<b>Consultation Response from KC Highways Development Management</b>		
<b>2025/93475 72 Northgate, Huddersfield, HD1 6AE</b>		
<b>Variation of Condition 2 (Plans) on previous permission 2024/92246 for redevelopment of existing site including demolition of existing car sales room (sui generis) and erection of new 2 storey police station (sui generis) with associated car parking, landscaping and infrastructure</b>		
<b>Date Responded:</b> 16/04/26	<b>Responding Officer:</b> M Zenner	<b>Responding Ref:</b> 5-8SE/37

The proposals are for an amendment to the previously approved application for the Police HQ. The submitted proposals appear to amend the access arrangements to incorporate the addition of vehicle barriers on the accesses from Broadway and Lower Fitzwilliam Street. As a result of the works there are also some elements of retaining walls and fencing that are proposed.

Drawing Title
Boundary Retaining Wall Sections Sheet 1

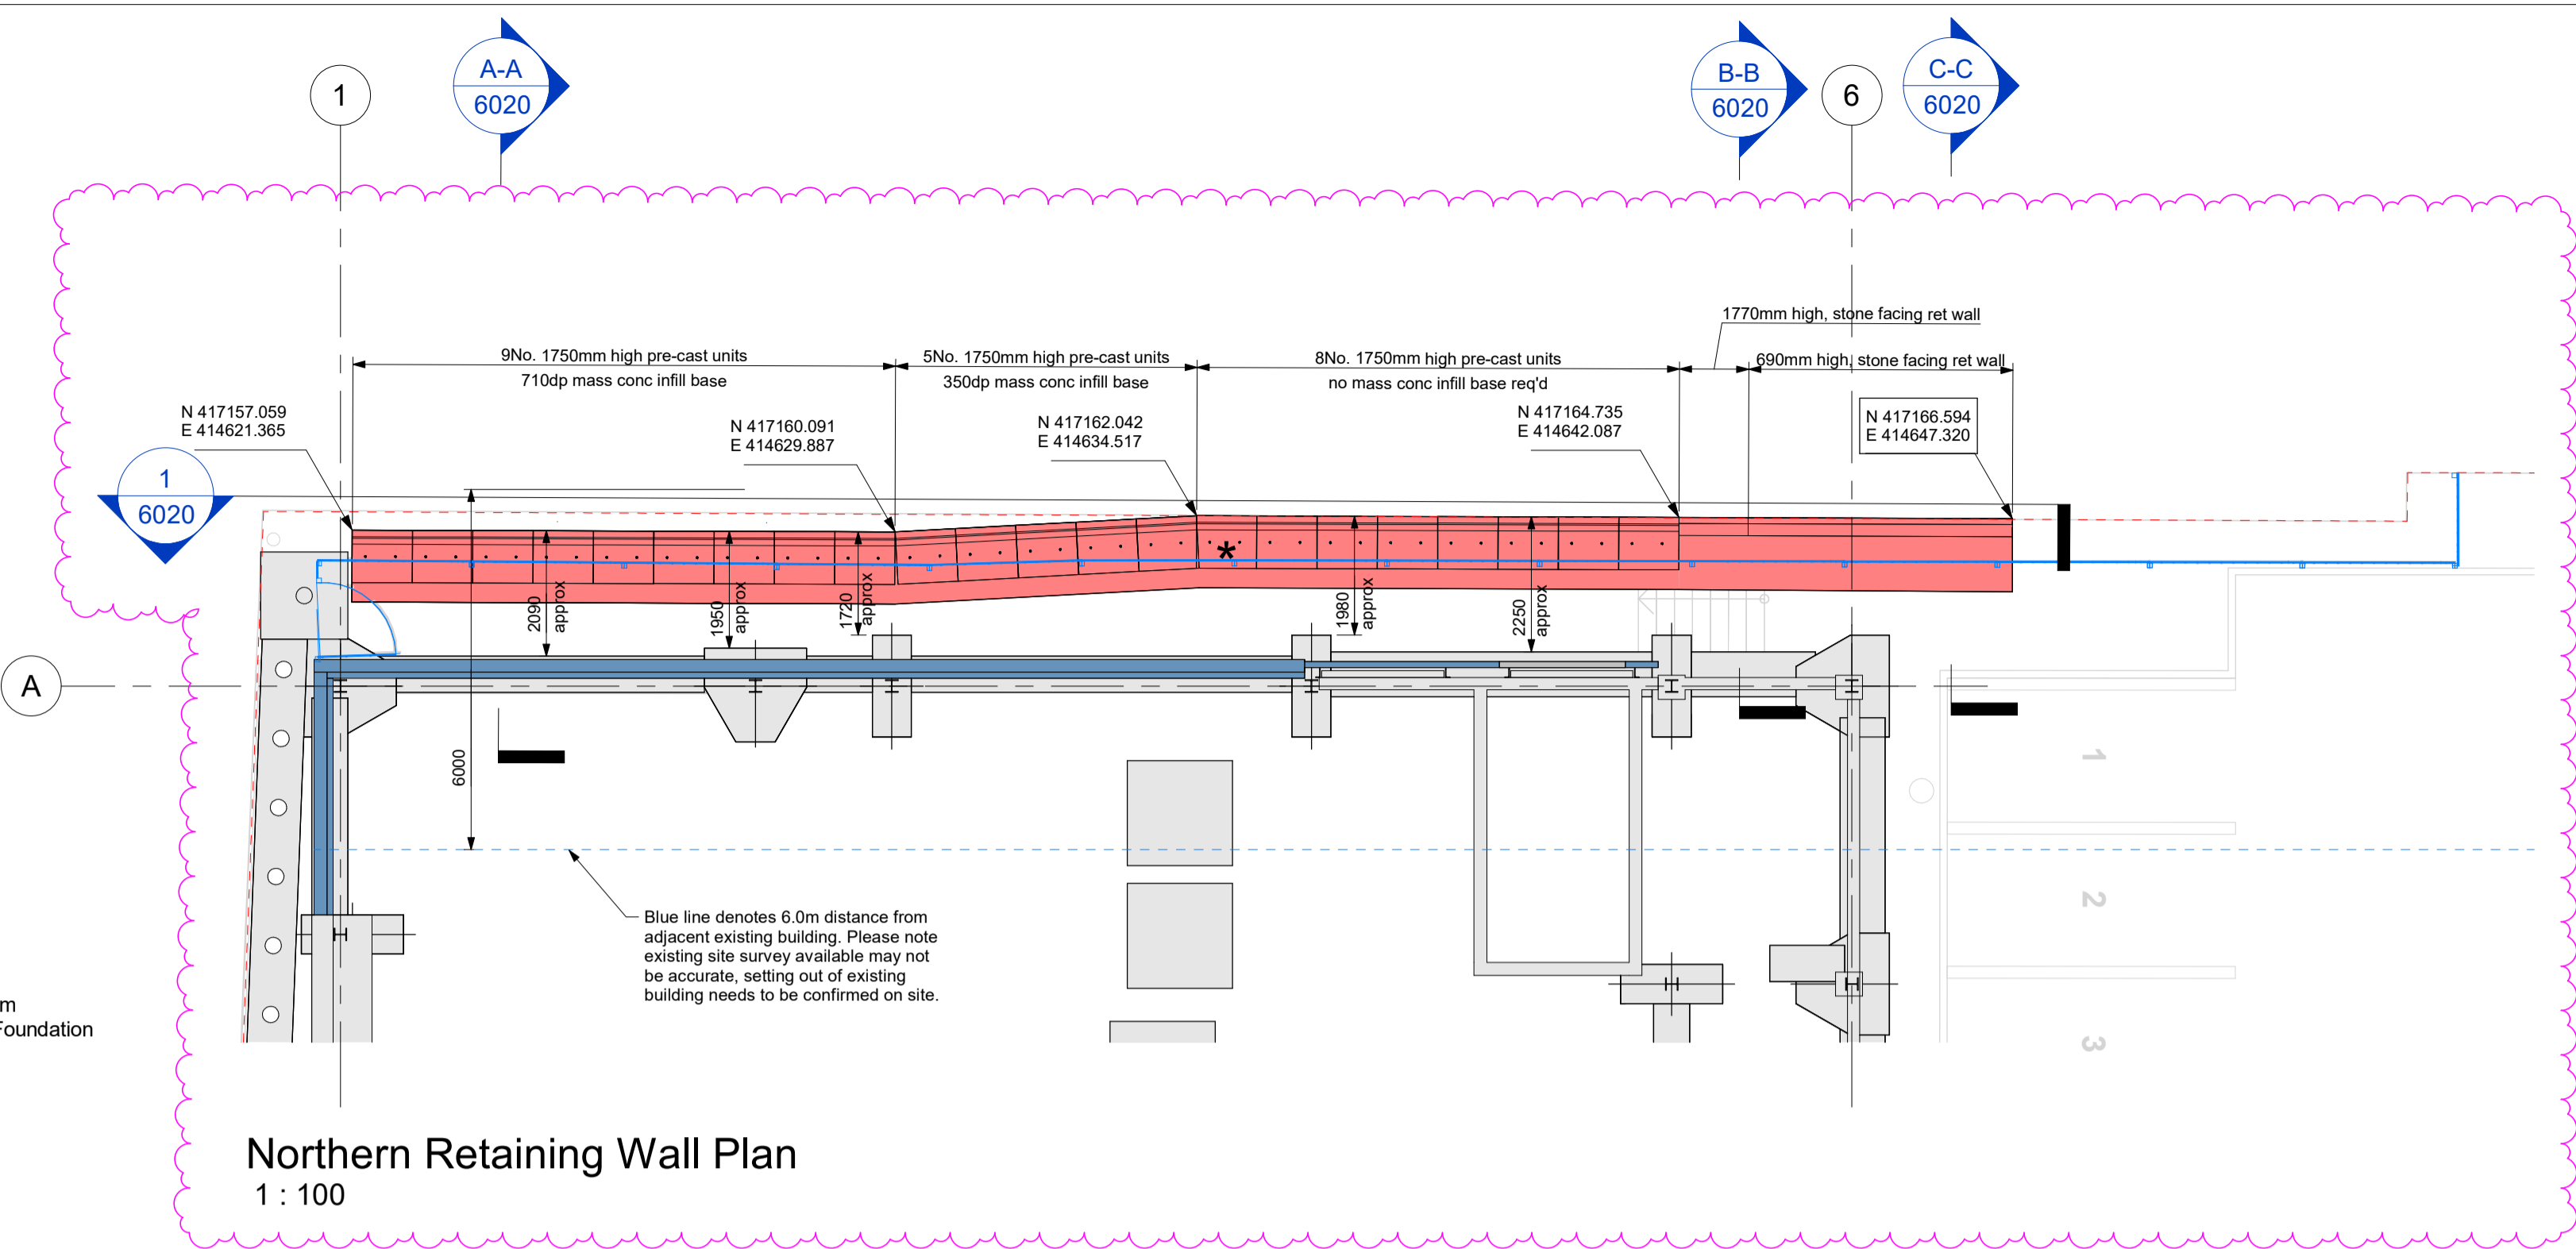
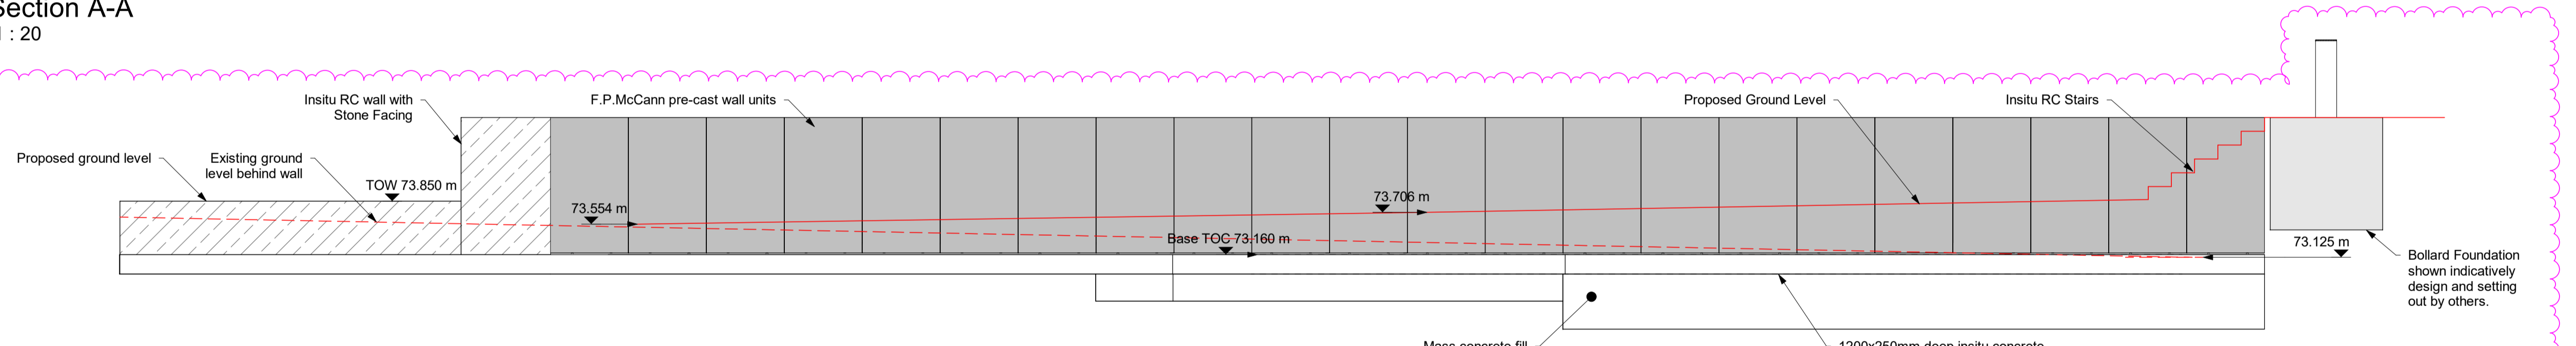
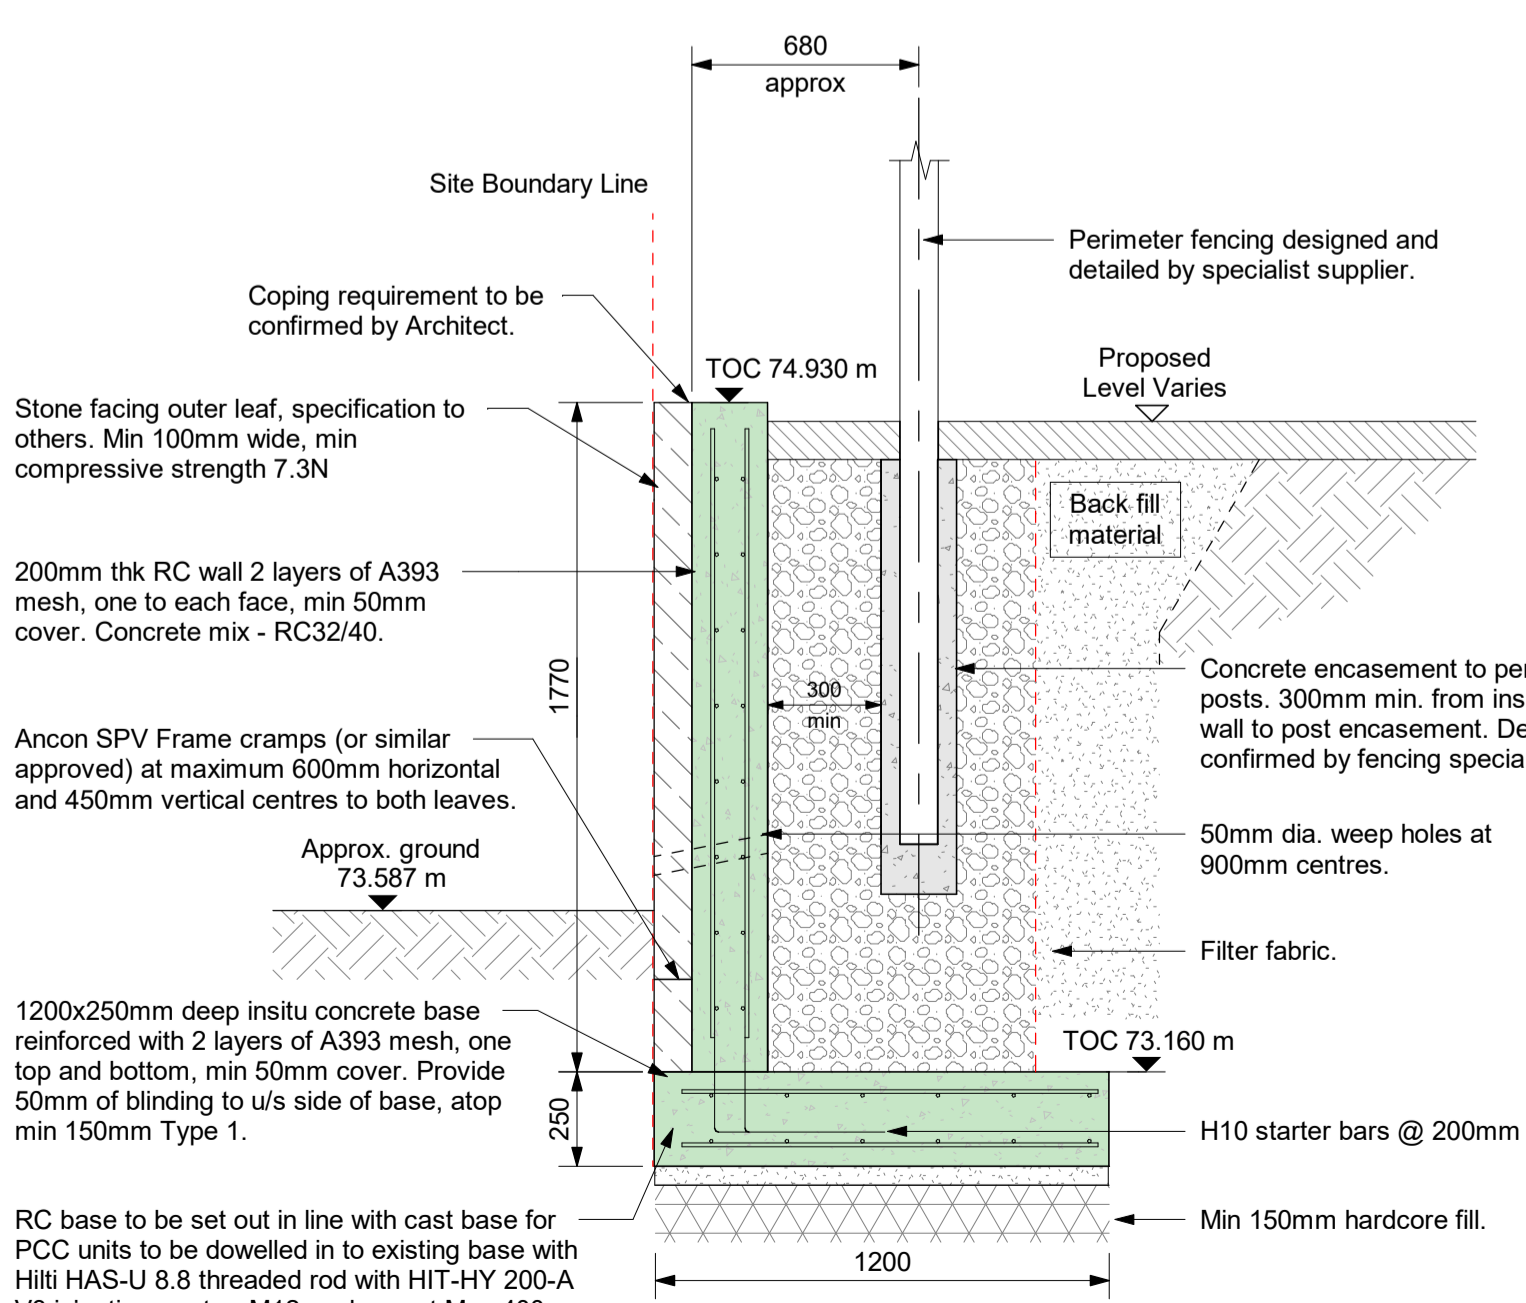
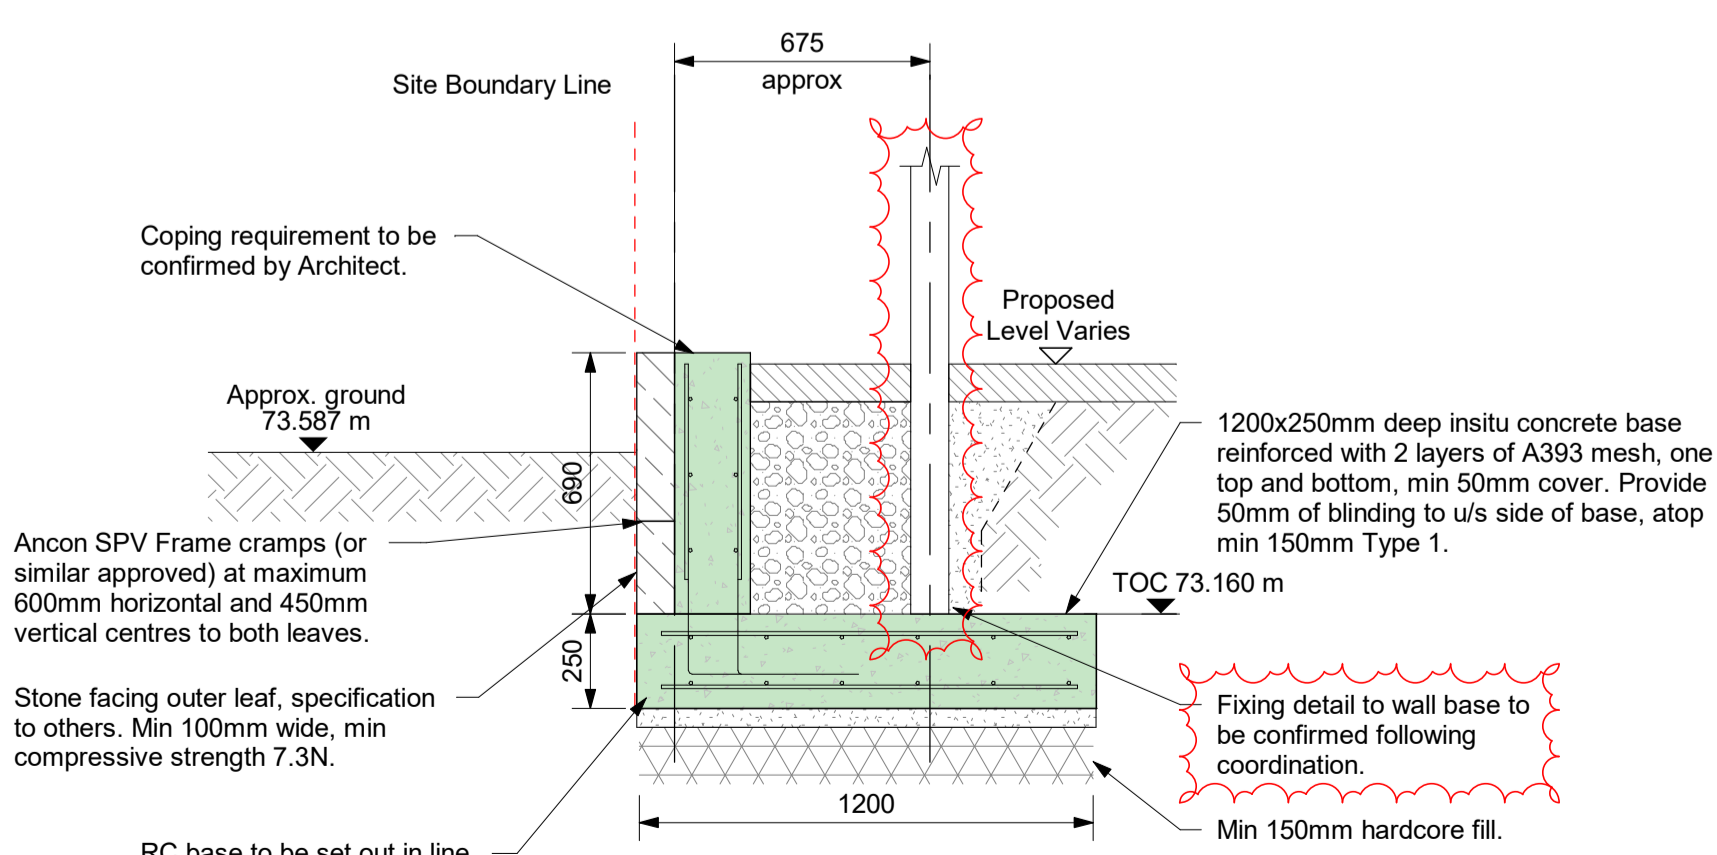
The vehicle access point from Lower Fitzwilliam Street proposes a barrier set back approximately 19m, stop lines on either approach and also a swipe / push button point on approach to the site. There is also the additional of a retaining wall on the west side of the access point which seems acceptable. The approach and alignment is on the straight and therefore should work acceptably.
